From: Andre Vernez
Sent: Thursday, 3 March 2022 3:21 PM
To: shaun.williams@planning.nsw.gov.au
Subject: Shoalhaven Starches Modification 21 - Modifications to Packing Plant & Other Modification Works - COMMENTS FROM SHOALHAVEN CITY COUNCIL ON REQUEST FOR ADVICE

MODIFICATION NO. 21

Development Engineering Comments/Requirements:

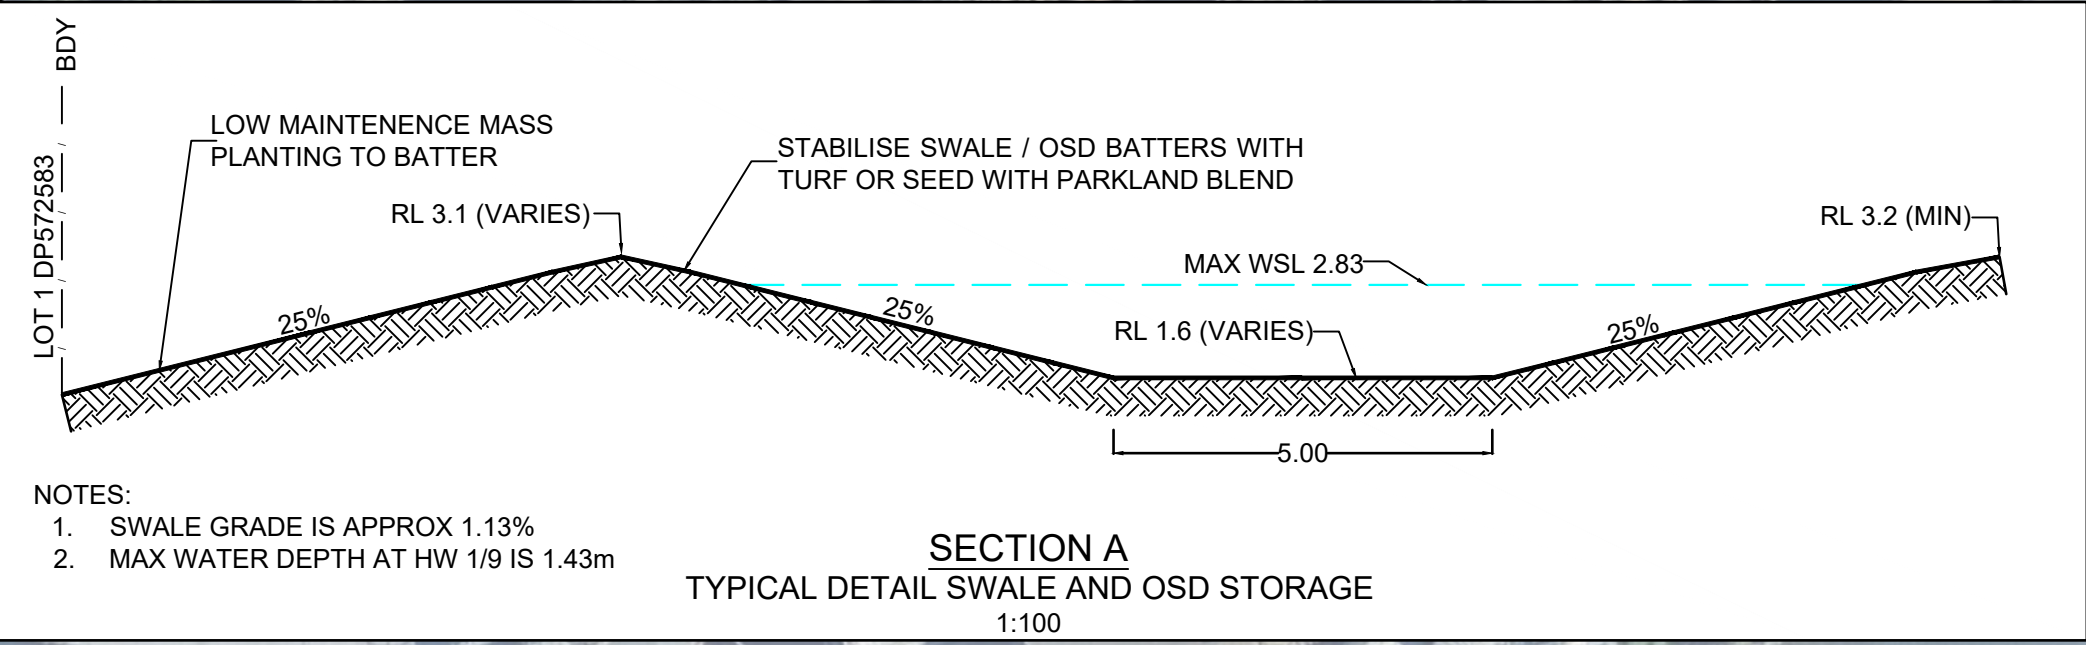
The Integrated Water Cycle Management Strategy (IWCMS) has been reviewed. The subject site is located outside of the Sydney Drinking Water Catchment and therefore acceptable solution A10.1 is not relevant. The site will be assessed against the acceptable solution A10.2 for development outside Sydney's drinking water supply catchments, pollutant load reduction must be a minimum reduction of the post development average annual load of pollutants in accordance with Table 3. Therefore, a revised IWCMS will need to be provided.

Further information is requested for the design of the OSD (e.g., typical section, depth of ponding). The IWCMS notes that the device is not located in landscaped areas and is in an 'out of bounds' area. Details will need to be provided to confirm how that area is to be managed and the Site Safety Protocols.
